January 3, 2022

**Re: Sequoia Apartments**  
**5130 Sequoia Rd. NW**  
**Traffic Circulation Layout**  
Architect's Stamp 12-17-21 (G11D058)

Marwa Al-najjar  
Associate Engineer, Planning Dept.  
Development Review Services

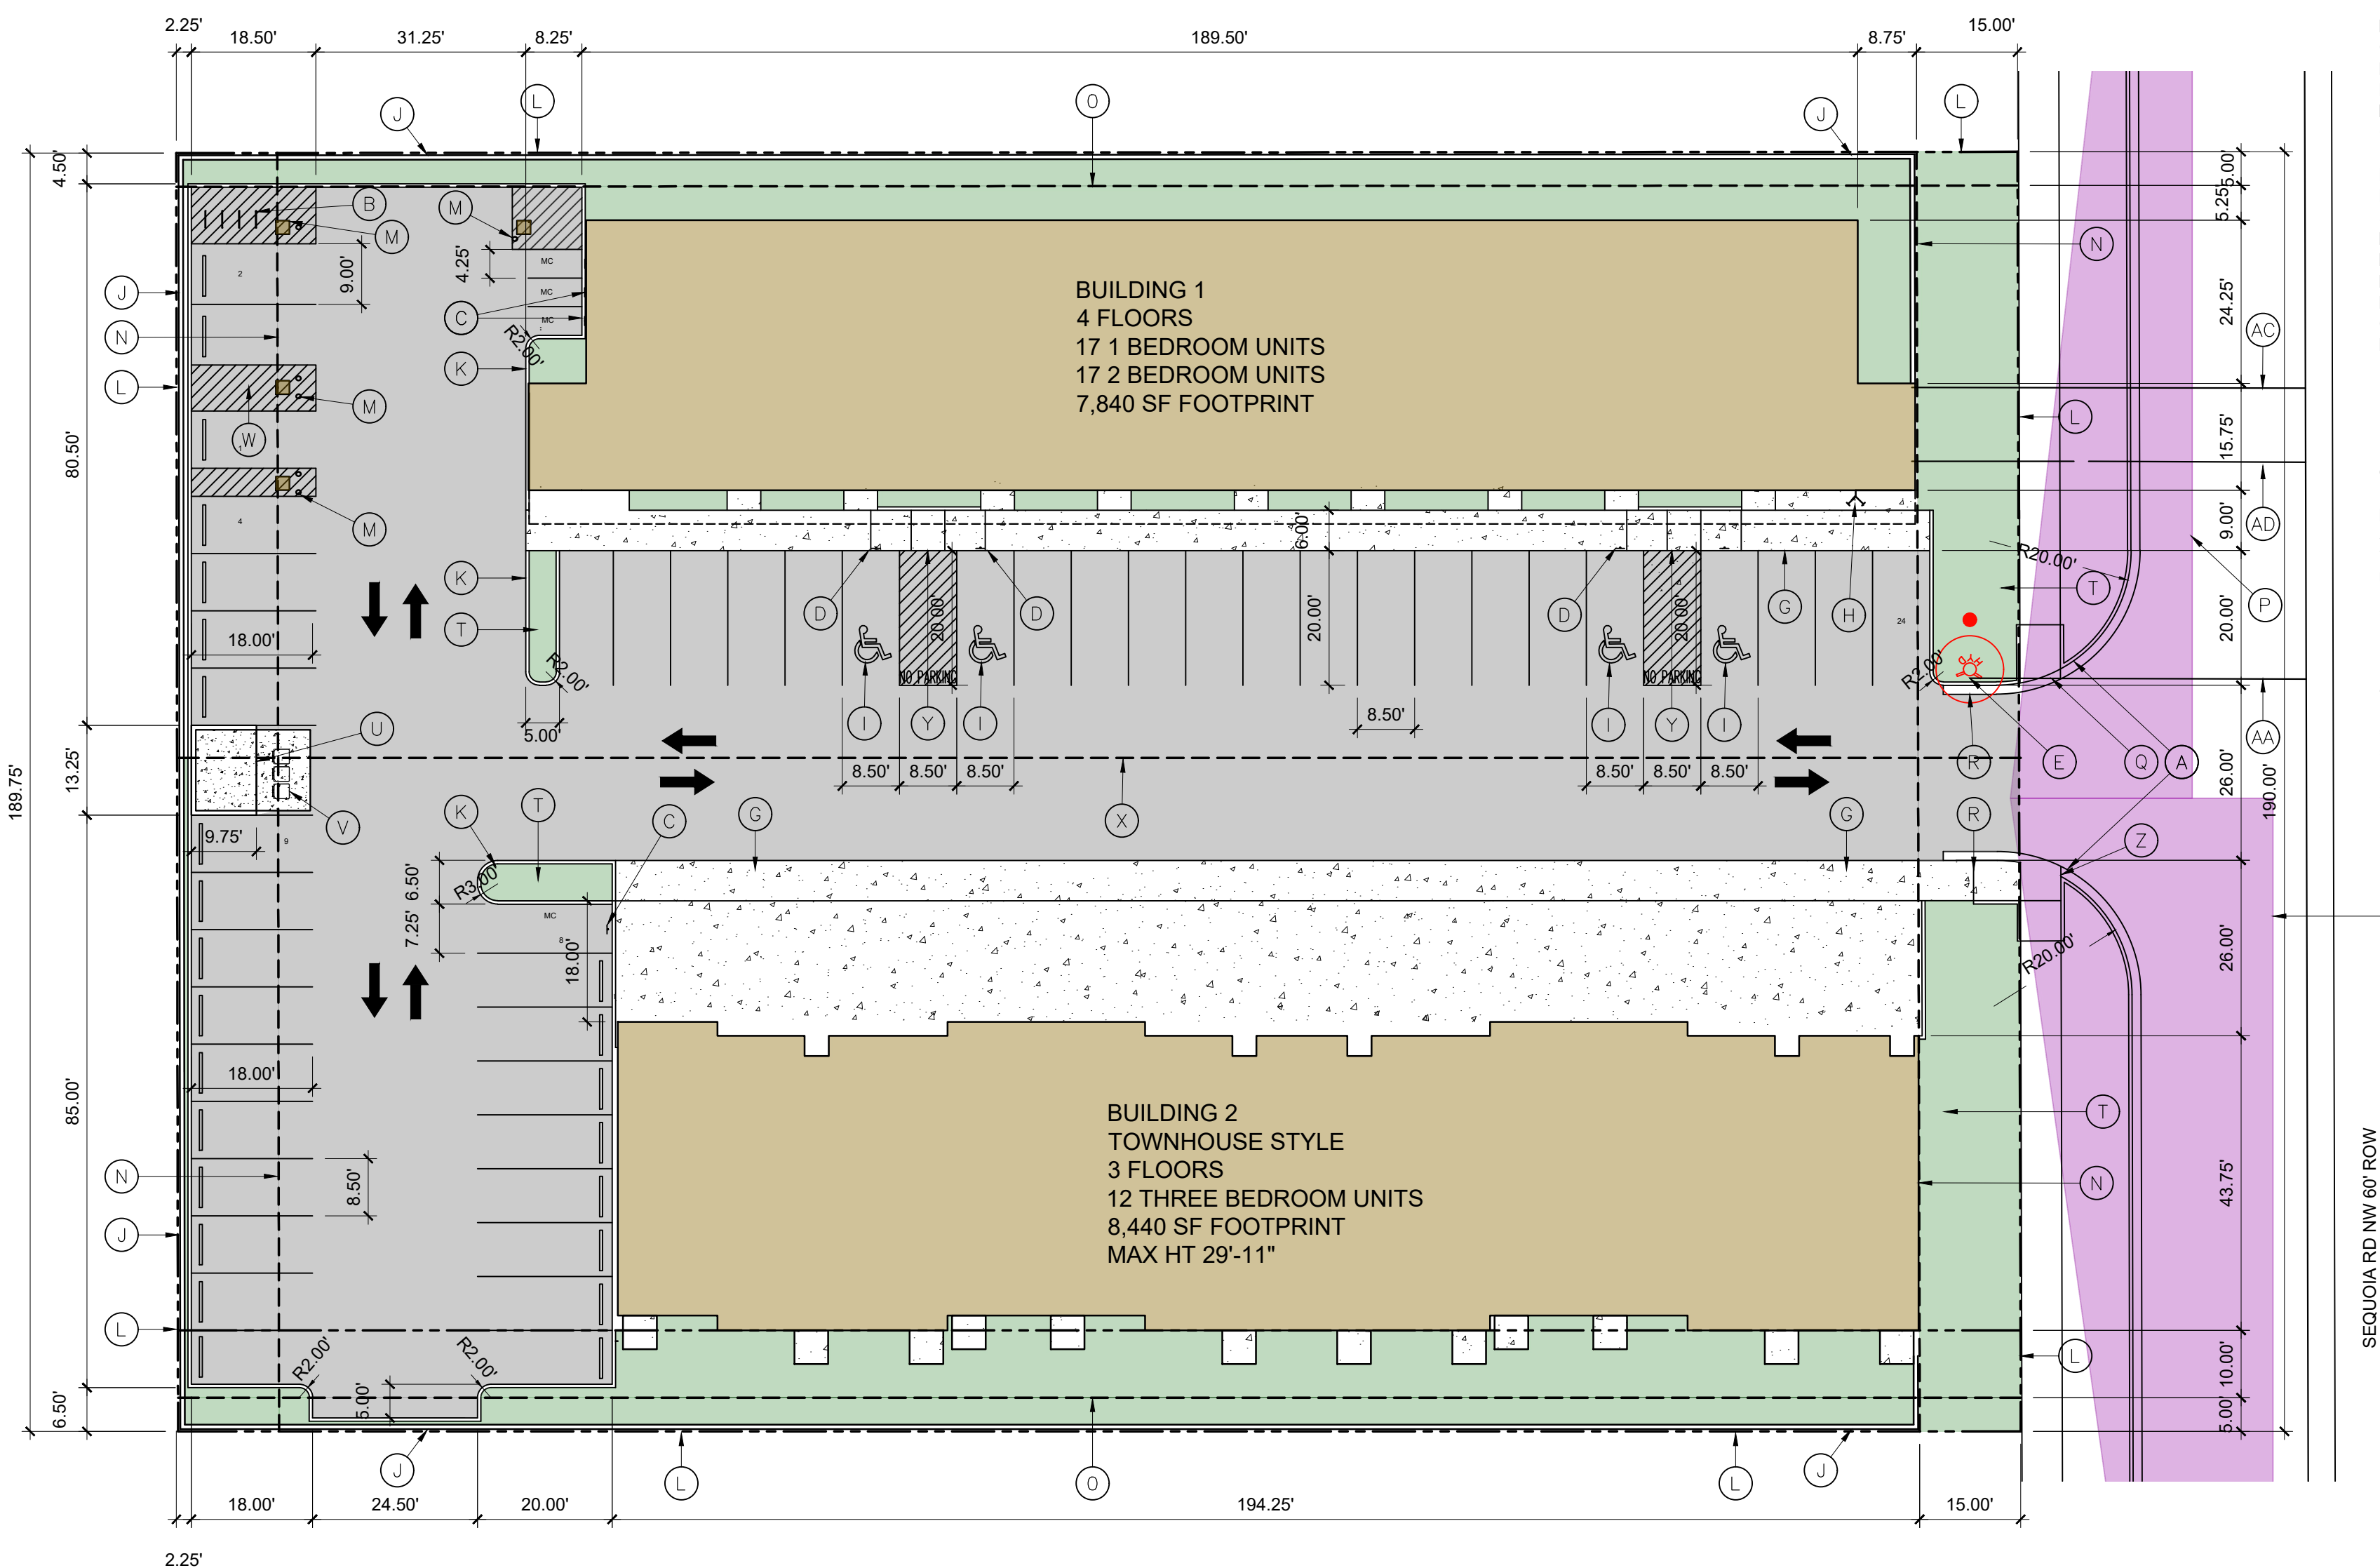
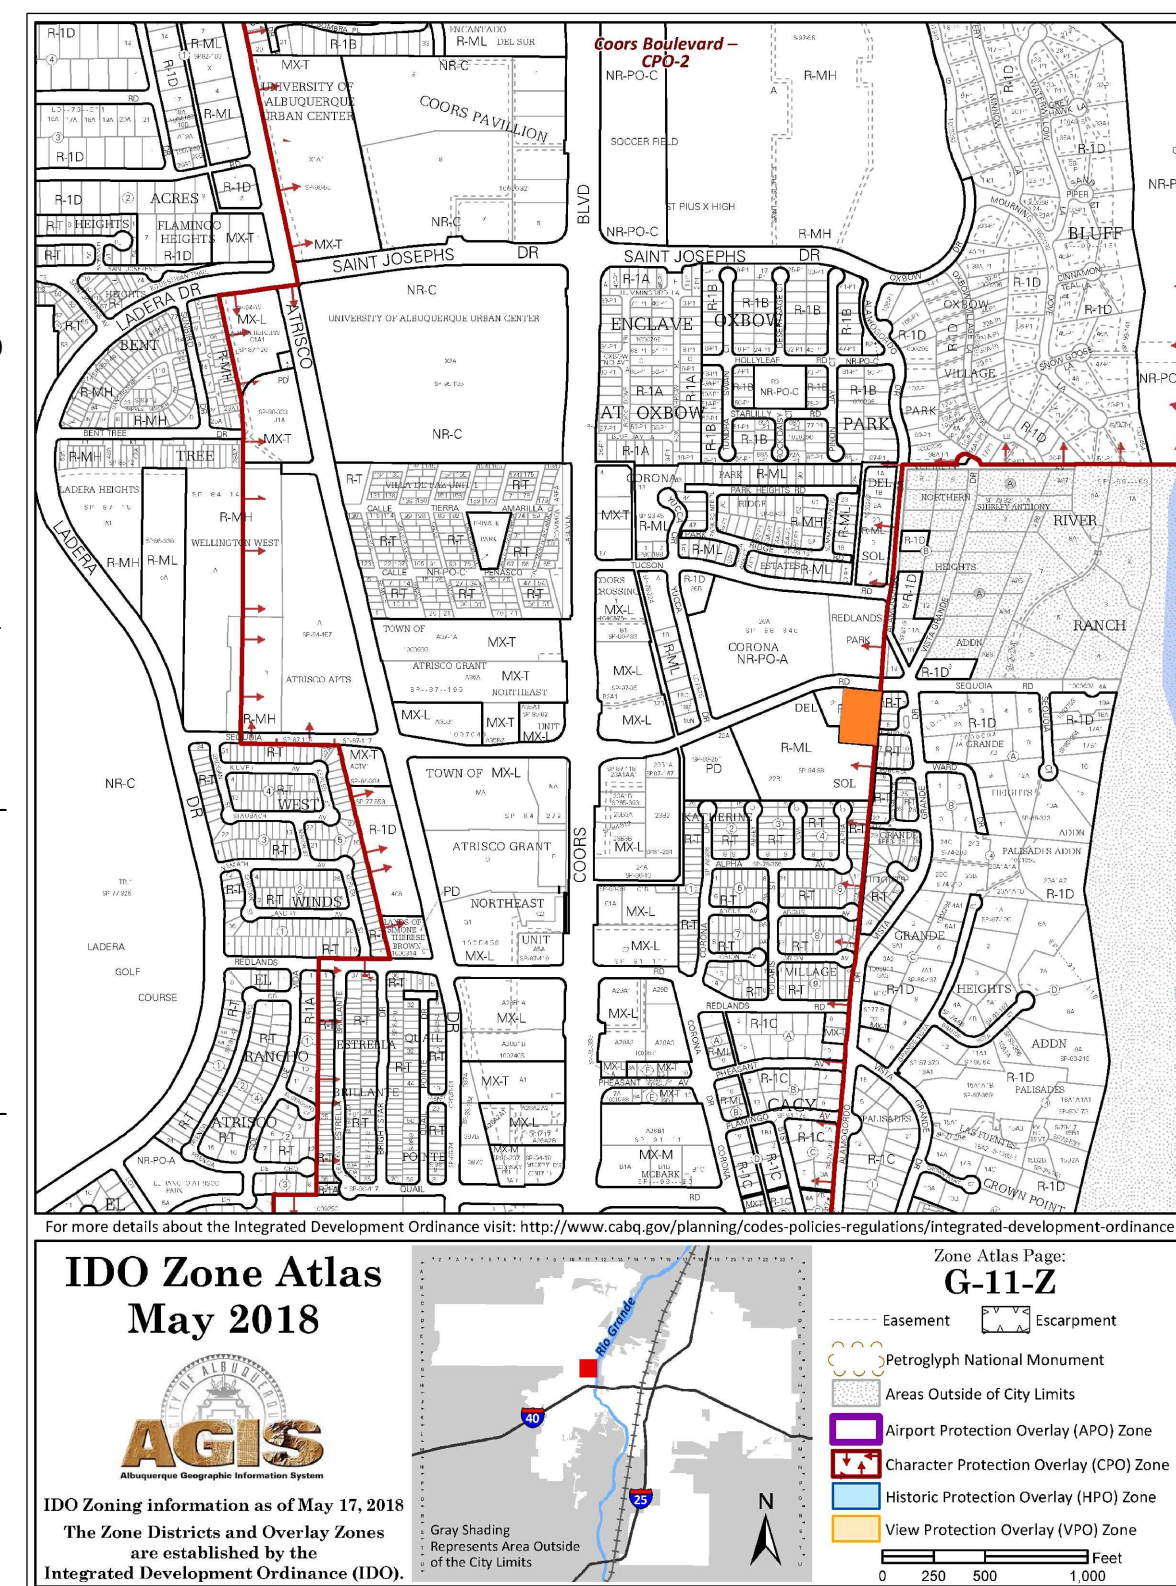
1. Identify the right of way width, medians, curb cuts, and street widths on Sequoia Rd.
2. Provide width for existing sidewalk.
3. Key note A has not been provided on the site plan.

4. List radii for all curves shown; for passenger vehicles. Radius for delivery trucks, fire trucks, etc. is 25 ft. or larger.
5. All parking spaces shall be dimensioned. Particularly, dimension the handicapped spaces. Dimension the length and width of all of the parking spaces and meet minimum requirements.

6. Per the IDO, a 6 ft. wide ADA accessible pedestrian pathway is required from the public sidewalk to the building entrances. Please clearly show this pathway and provide details.

7. A 6-foot sidewalk is required from the handicapped spaces to building entrances. Label all walkway widths and show doorways.
8. Parking areas shall have barriers to prevent vehicles from extending over public sidewalk, public right-of-way, walls or abutting lots.

9. Key note Q: Provide another curb ramp design for the ADA aisle.
10. Refuse vehicle maneuvering shall be contained on-site. The refuse vehicle shall not back into the public right of way; provide a copy of refuse approval.

11. Provide a copy of fire marshal approval.
12. It is not apparent what type of pavement surface is being proposed. A hard driving surface will be required as part of this proposed project for parking area and drive aisles.

13. Provide dimensions for clear sight triangle.
14. Provide Motorcycle parking sign for MC parking space south of Building 2.

1. Provide pavement marking Arrows for the two-way drive aisle. And provide details for those Arrows.
2. Why you are providing "DO NOT ENTER" sign? And where it will be placed?
3. Add a note stating "All broken or cracked sidewalk must be replaced with sidewalk and curb & gutter." A build note must be provided referring to the appropriate City Standard drawing.
4. Please provide a letter of response for all comments given.
